Date: 27/01/2026**Project: 372-374 Mann Street & 35-37 Dwyer Street, North Gosford NSW****NSW Government ref No. SSD-69773460****Client: The Trustee for Stockbridge Property Unit Trust****RE: Response to Department of Planning, Housing and Infrastructure RFI letter (Dated 27 November 2025) – Engineering matters**

We are writing in response to the civil/stormwater management-related items mentioned in the RFI letter.

LONGITUDINAL SECTION NEW ROAD CENTRELINE

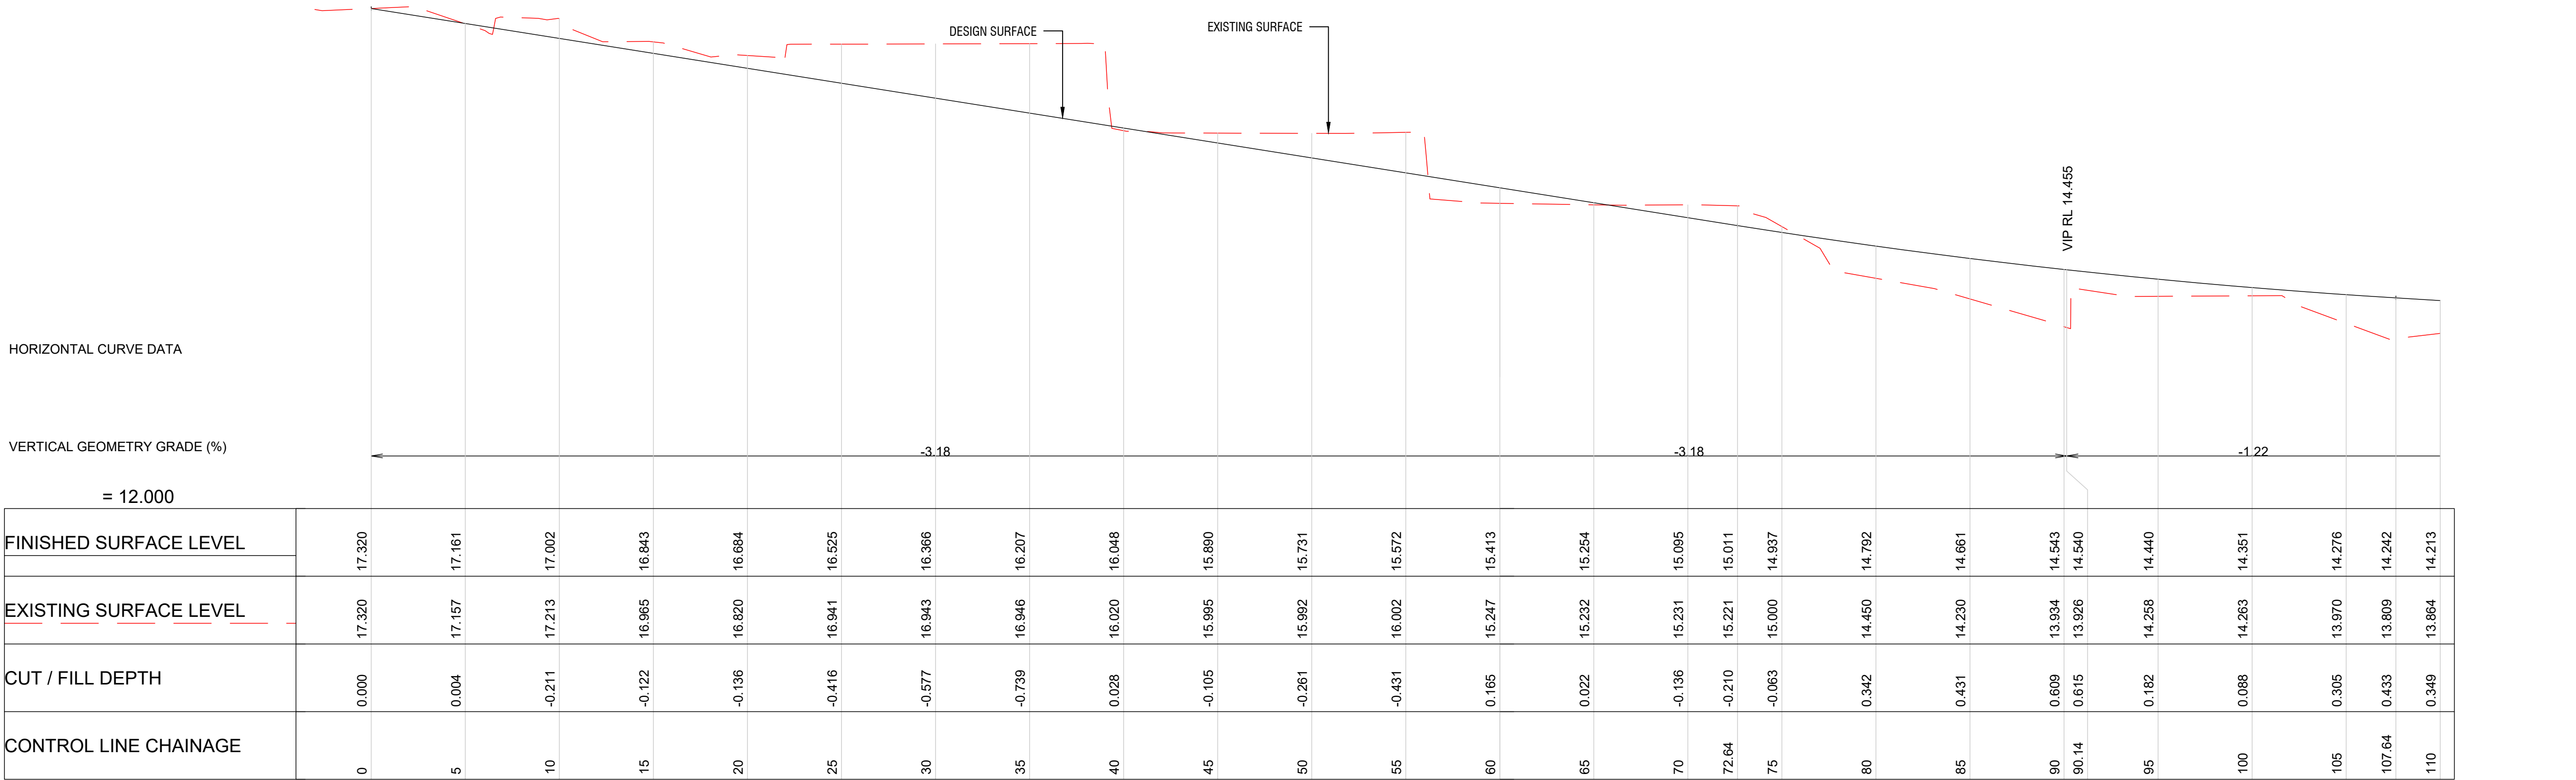
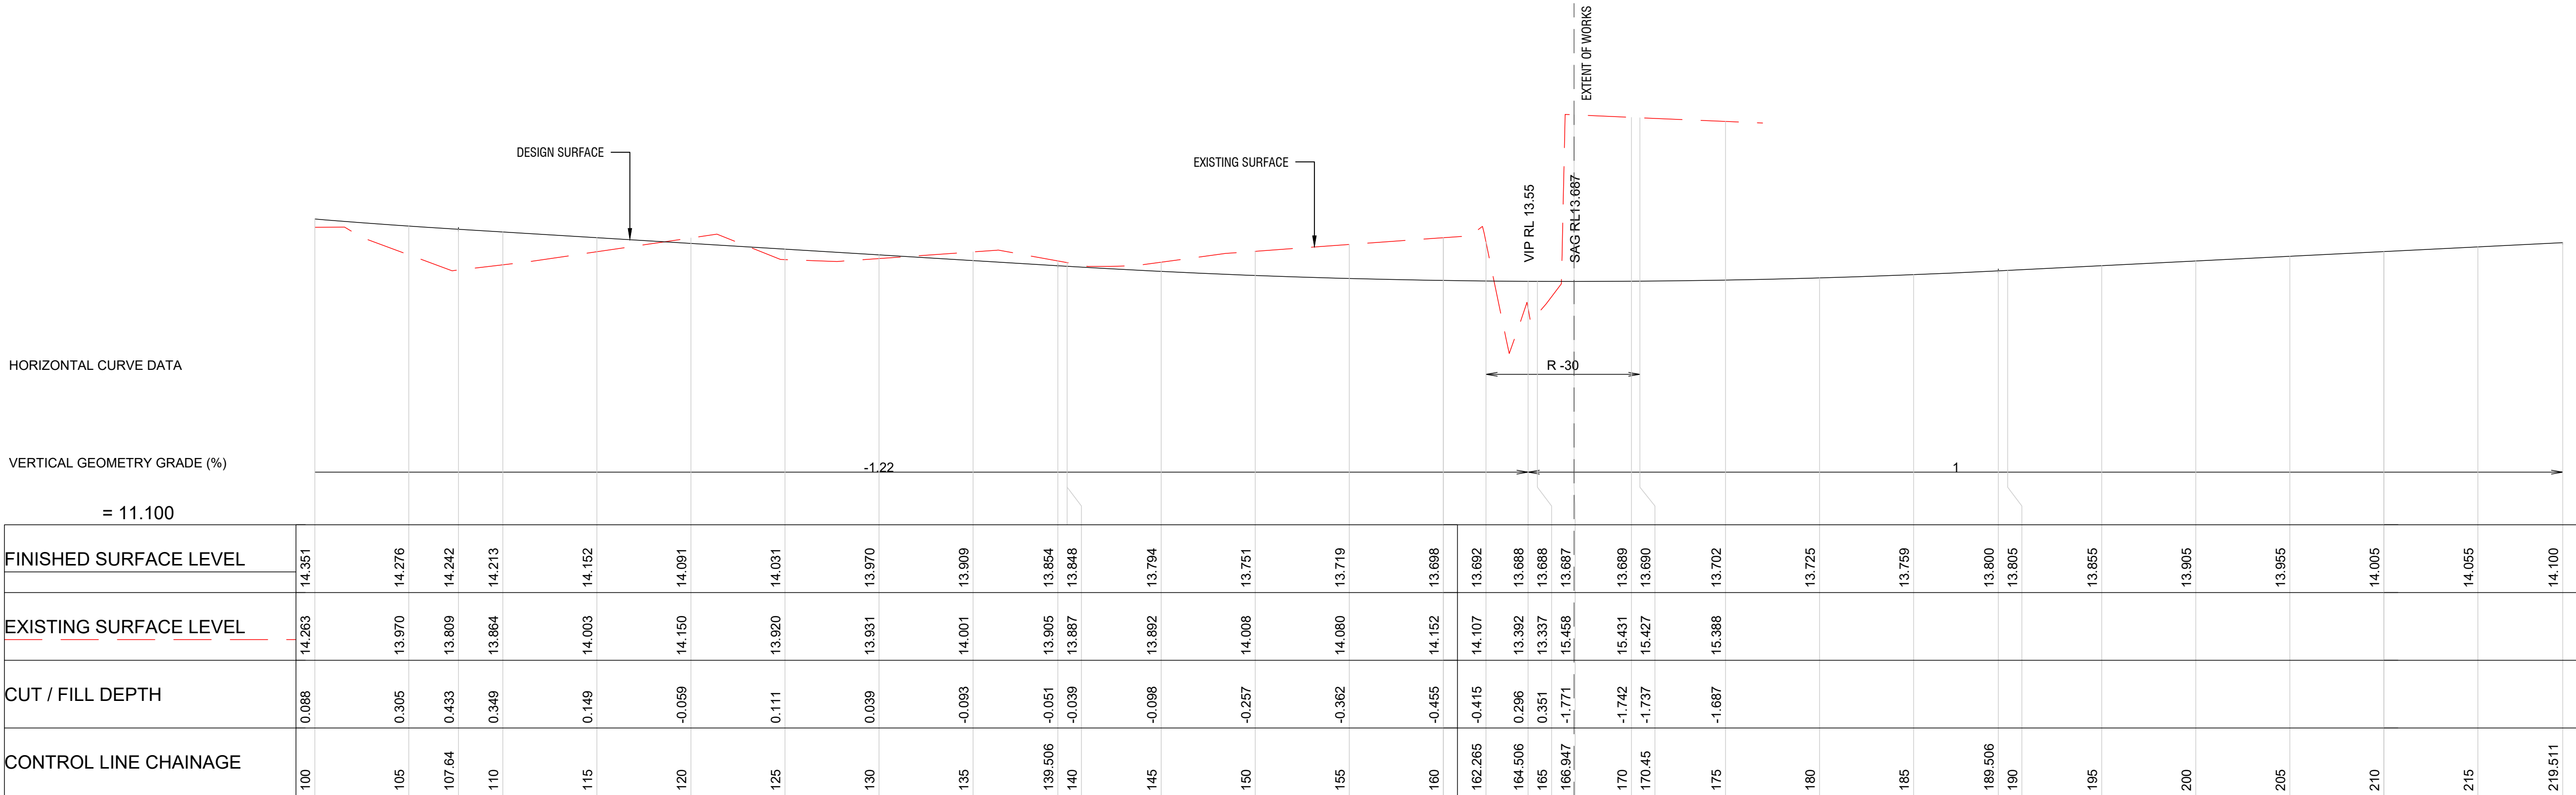
- *RFI #4 – reviewing the grades of the proposed private road to ensure that stormwater flows from Dwyer Street do not enter the site via the private road, noting this may involve changes to footpath levels and development levels in the vicinity of the private road.*

Response: Private road longitudinal section altered to introduce a crest on the boundary line at the intersection of private road and Dwyer Street to ensure that stormwater flows from Dwyer Street do not enter the site.
